Re: Vollmer MVEA Substation at Sterling Ranch  
EPC File # EX201

Please accept this letter and attachments in response to specific agency review comments provided through the EPC Development Services Department EDARP portal regarding the application referenced above. The comments requiring specific response are listed below:

4. The preliminary plat provided several comments through out. The following is a summary of the comments and response provided on the revised plat attached hereto:

# MVEA SUBSTATION AT STERLING RANCH EXEMPTION SURVEY PLAT

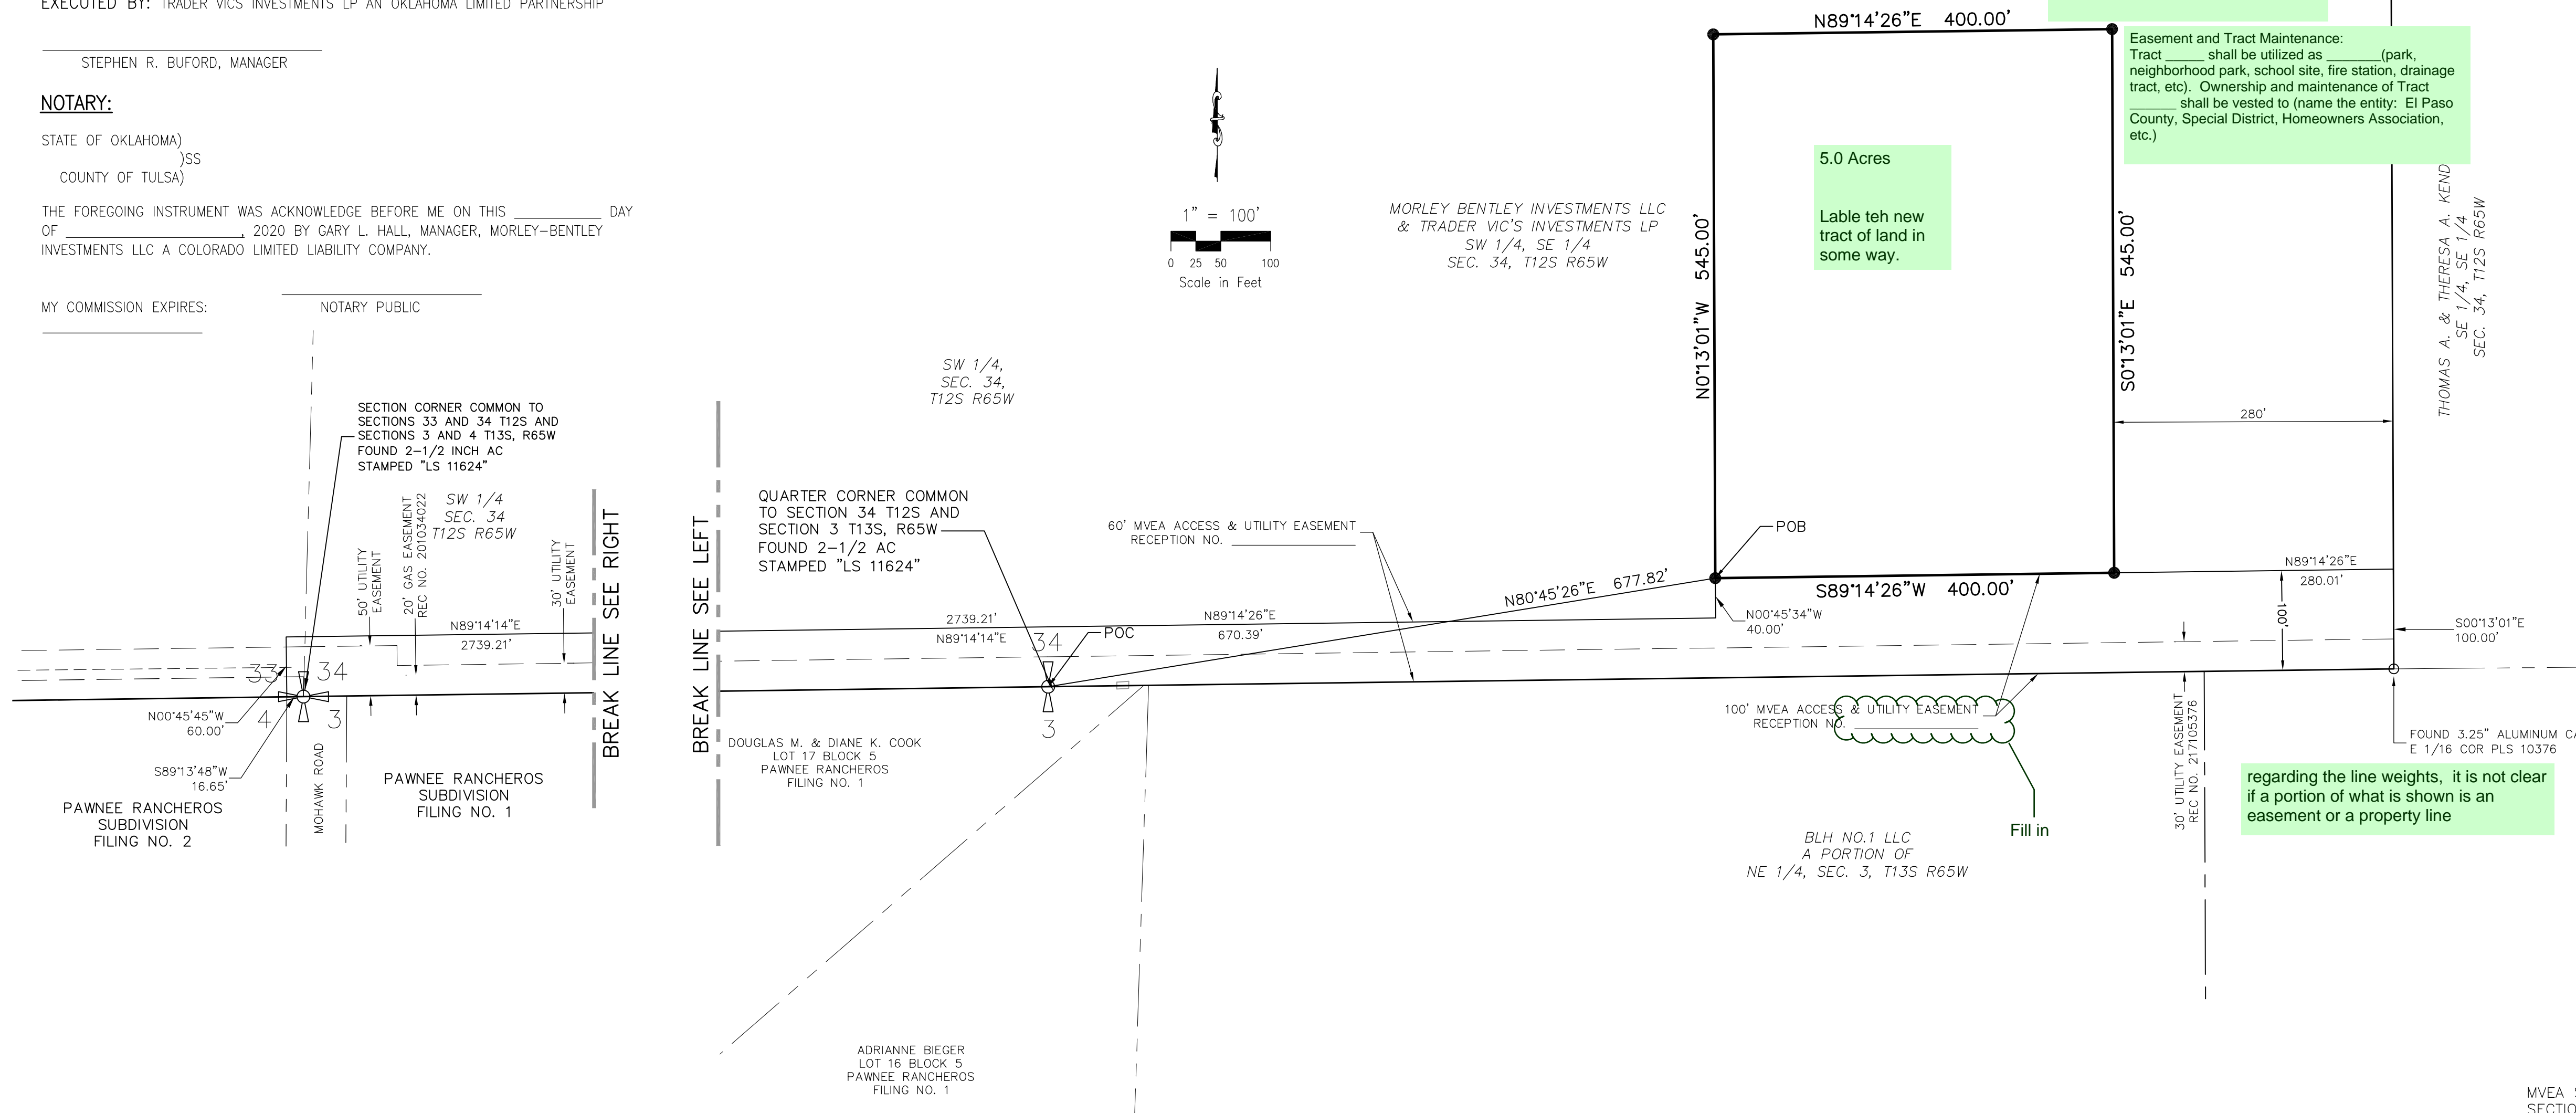
1. *"Identify basis of bearing" :*

2. *"For a total of \_\_\_\_\_ acres"*

3. *"Add the following note to the General Notes on the cover sheet: All easements that are dedicated hereon for public utility purposes related to gas and electric shall be subject to those terms and conditions as specified in the instrument recorded at Reception Number 212112548 of the records of El Paso County, Colorado. All other easements or interests of record affecting any of the platted property depicted hereon shall not be affected and shall remain in full force and effect."*

4. *"Considering the development in this area, if this access and utility easement is to be a permanent roadway it should be named. Street naming documentation can be found at: <http://elpasoteller911.org/StreetNaming>"*

5. *"All standard notes are still required on a exemption plat"*

6. *"Note Regarding Stormwater Drainage"*

7. *"Addresses"*

8. *"Easement and Tract Maintenance etc"*

9. *"Label the new tract \_\_\_\_"*.

10 *"BODD Signature Block"*

11. *"line weights \_\_\_\_\_ etc."*

12. add *" EX 20-001"*.

Addressed: This is shown in Note 1, and next to the drawing line work as described.

Addressed: The Legal Description on the revised plat now says "SAID PARCEL CONTAINS A CALCULATED AREA OF 5.00 ACRES"

*Not Addressed. This reception number refers to Colorado Springs Utilities easements. CSU utilities will not be necessary for this parcel. CSU only provides gas service in this area, and it is not needed for an electric substation.*

*Addressed : As requested by the Pikes Peak Regional Building Department, a temporary address of 9167 Mohawk Road has been identified on the revised plat attached hereto. Future Preliminary Plans will be submitted to reflect and name the adjacent roadways. This substation will be accessed by the access easements shown. This easement will be recorded by separate instrument.*

Addressed. Additional standard notes have been added.

Addressed. The note has been added to the drawing.

Addressed. The note has been added to the drawing. This is now stated in Survey Note # 6 on the revised plat

Not addressed. This parcel is private and will be owned and maintained by MVEA. No parks, or other tracts exist.

Addressed. The tract is now labeled on the revised plat: " MVEA SUBSTATION , 5.00 ACRES, 9167 MOHAWK ROAD

Addressed. has been added to revised plat

Addressed. have been addressed on revised plat

Addressed. has been added to the revised plat
